Application Ref:	2025/0603			 Ribble Valley Borough Council www.ribblevalley.gov.uk
Date Inspected:	N/A	Site Notice:	N/A	
Officer:	SK			
DELEGATED ITEM FILE REPORT:				NMA APPROVAL

Development Description:	Non-material amendment to application 3/2024/0990 involving change in window/door positions and change of materials on entrance elevation (stone instead of render).
Site Address/Location:	Barrowbridge House Club Street Barrow BB7 9AY

Client Mr S Gill		
Project Proposed Development at Barrow Bridge House Club Street Barrow Clitheroe BB7 9AY		
Drawing Title Plot 4 Proposed Plans and Elevations		
Scale 1:50/100 @ A2	Date Mar 2024	Drawn LFR
READ DESIGN LTD		
161 - 05 D

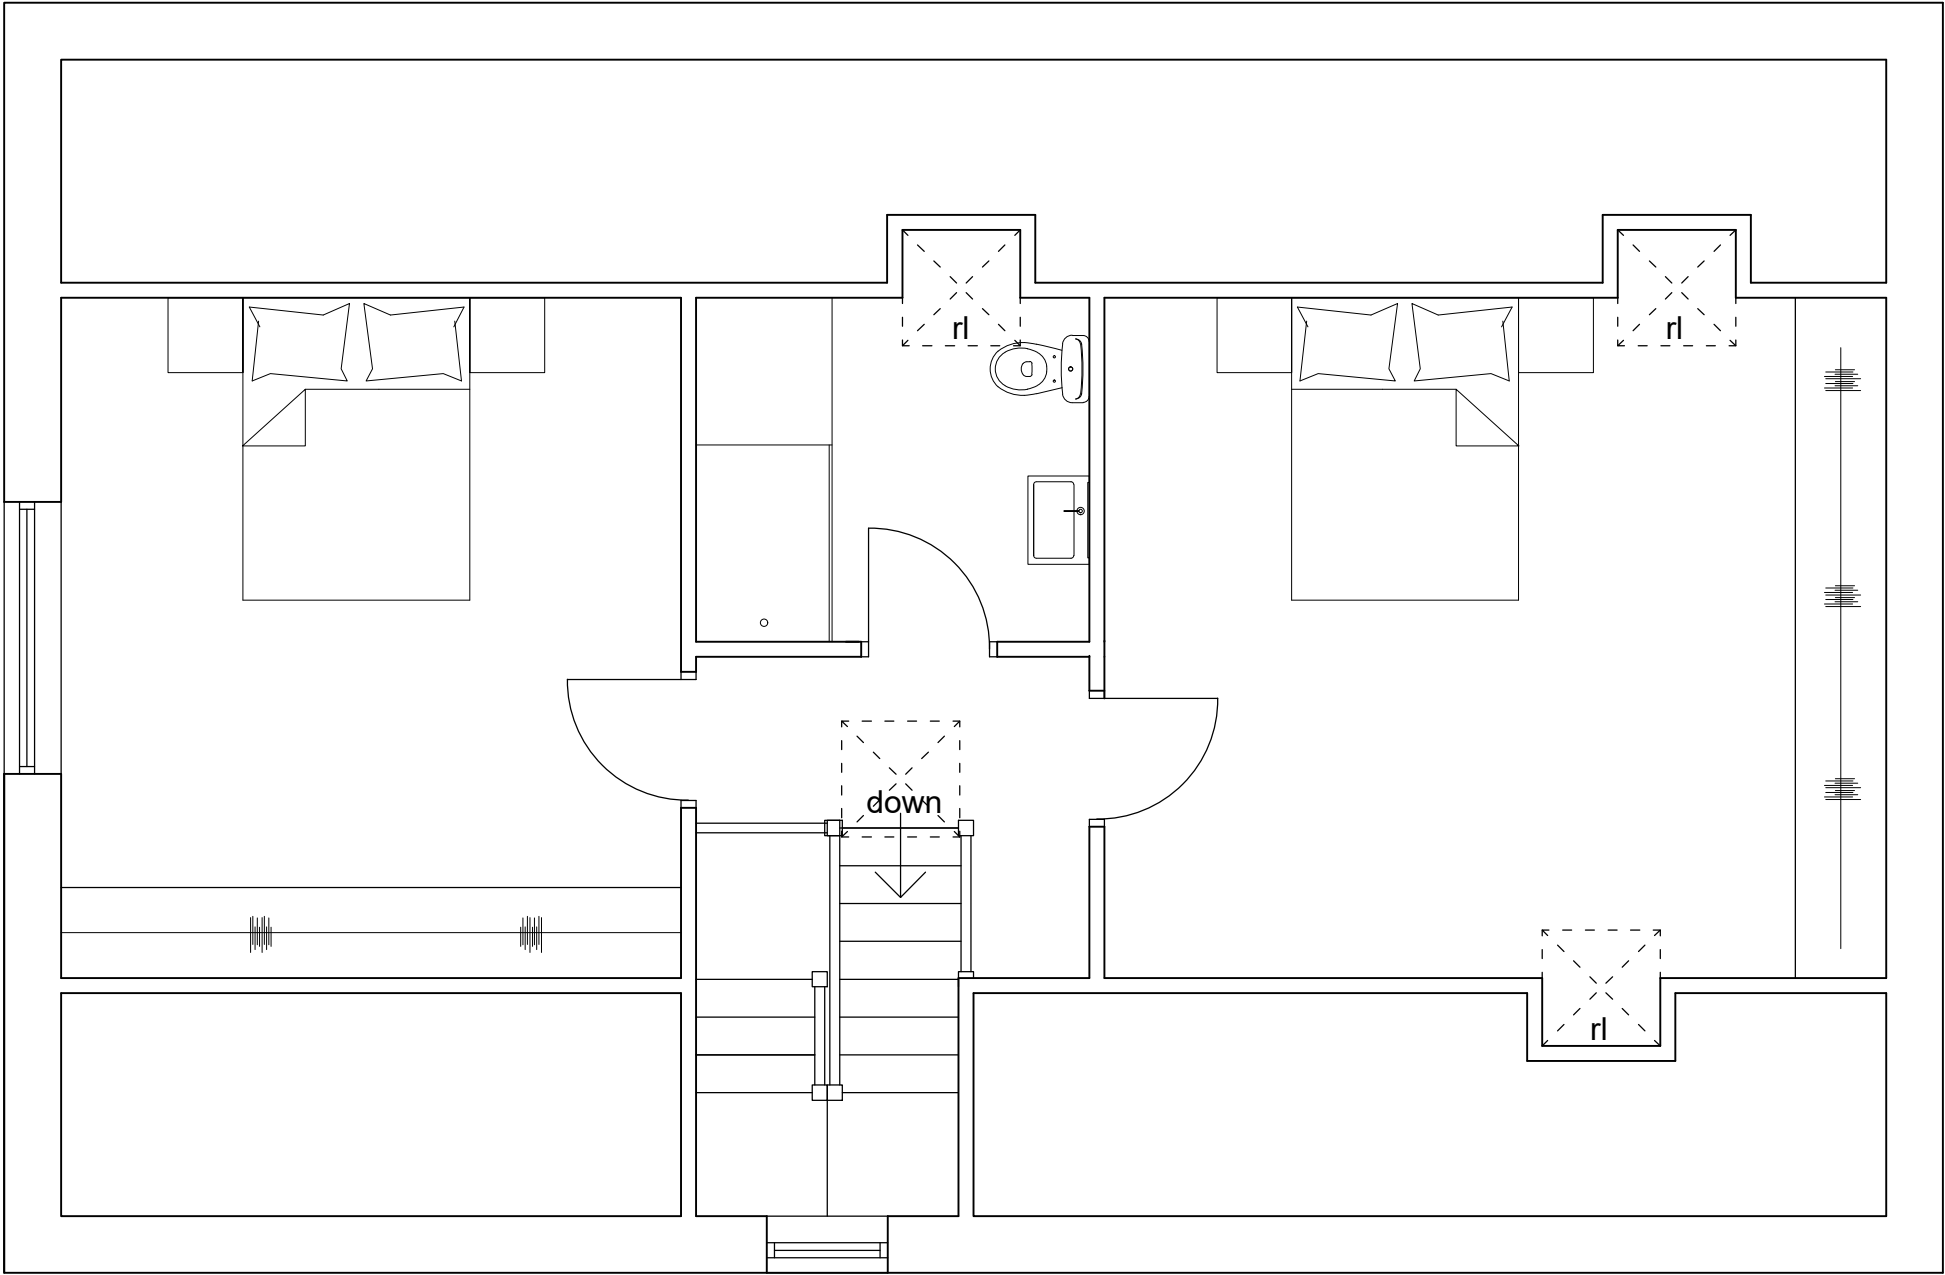
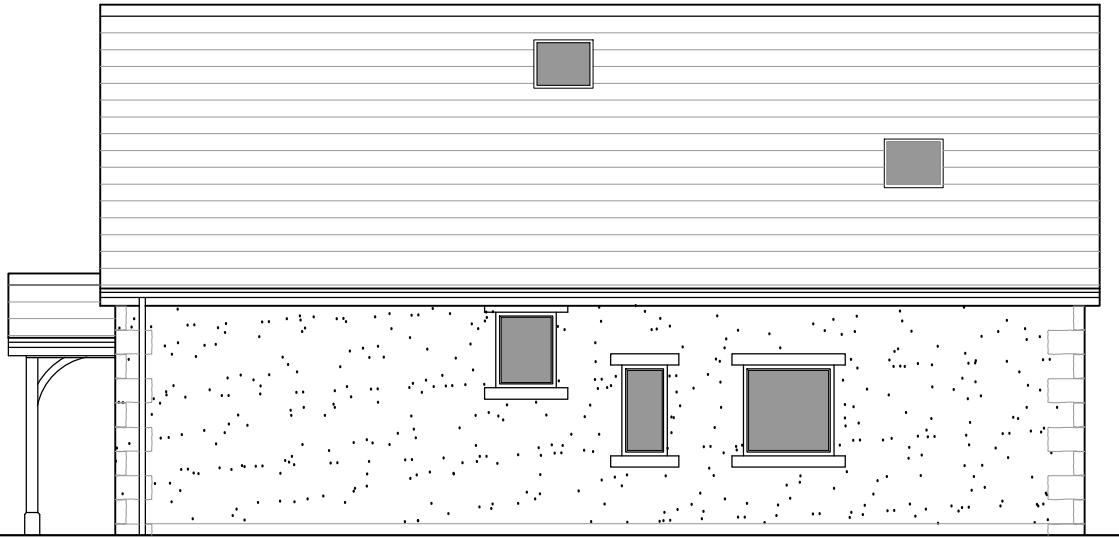
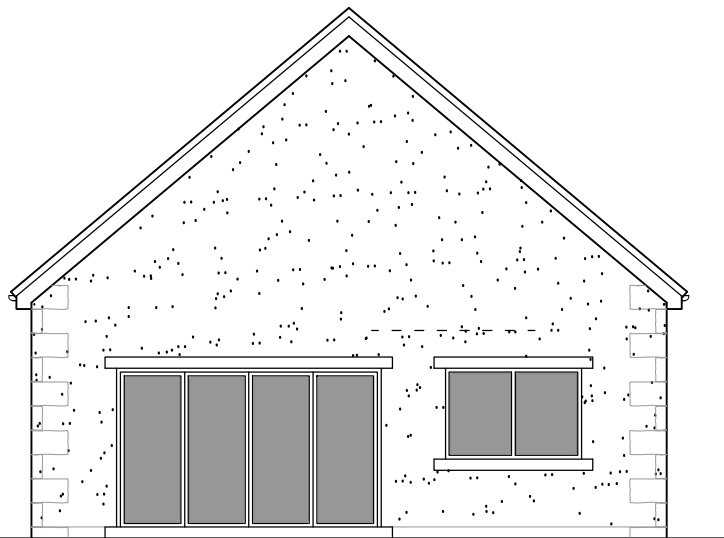
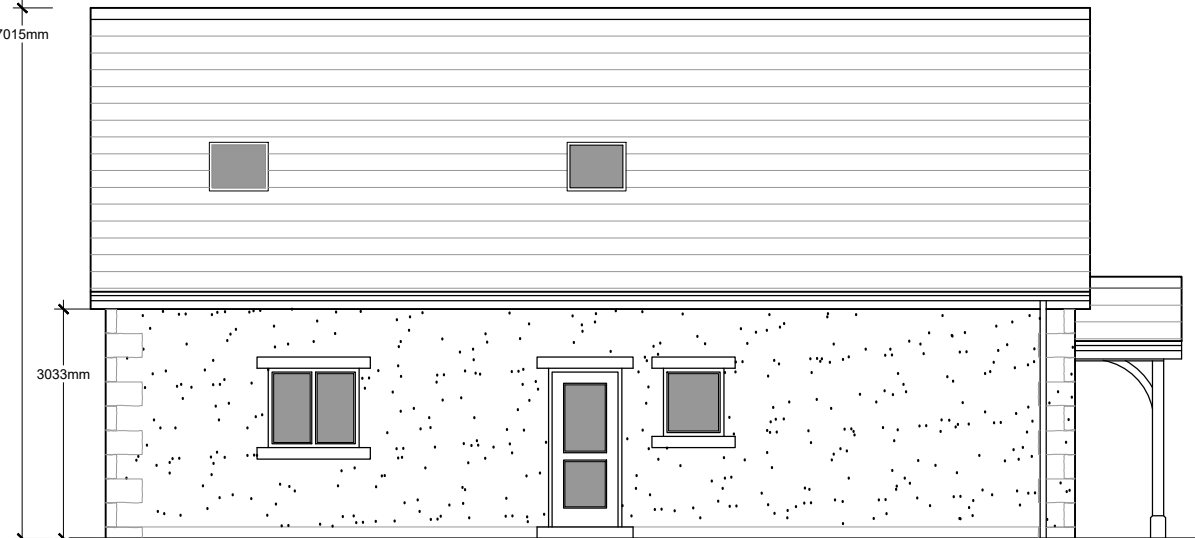
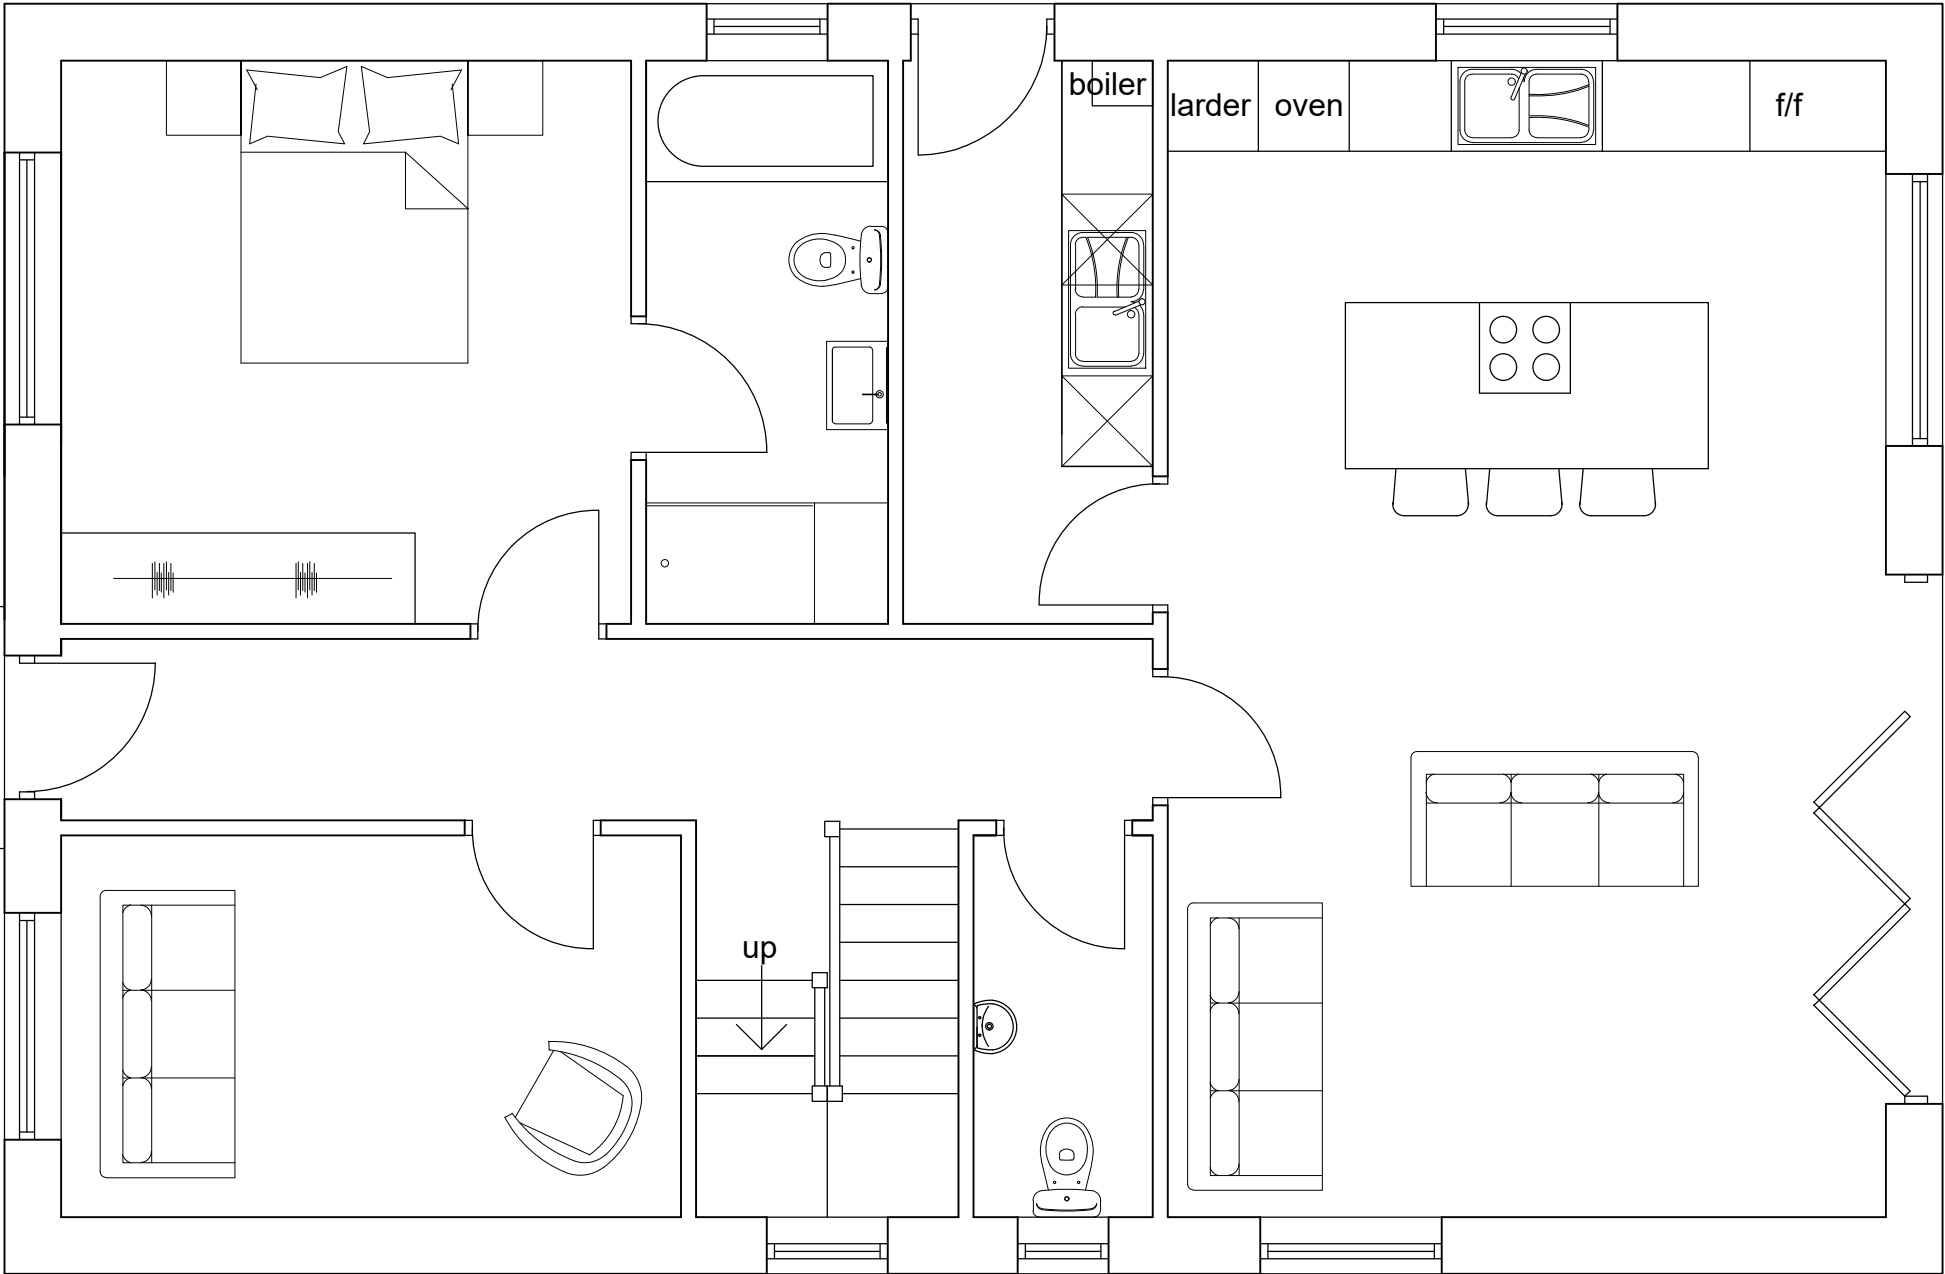
Plot 04:

North-East Elevation:

- Amendment to window locations and introduction of window to serve newly located internal staircase.
- Head and sill detailing added

North-West Elevation:

- Introduction of new window at ground floor
- Use of stone on elevation in-lieu of render
- Head and sill detailing added

South-East Elevation:

- Head and sill detailing added

South-West Elevation:

- Head and sill detailing added
- Window omitted
- Velux and windows configuration altered

Internal Floorplan:

- Revised location of internal staircase
- Snug introduced at ground floor
- First Floor layout reconfigured
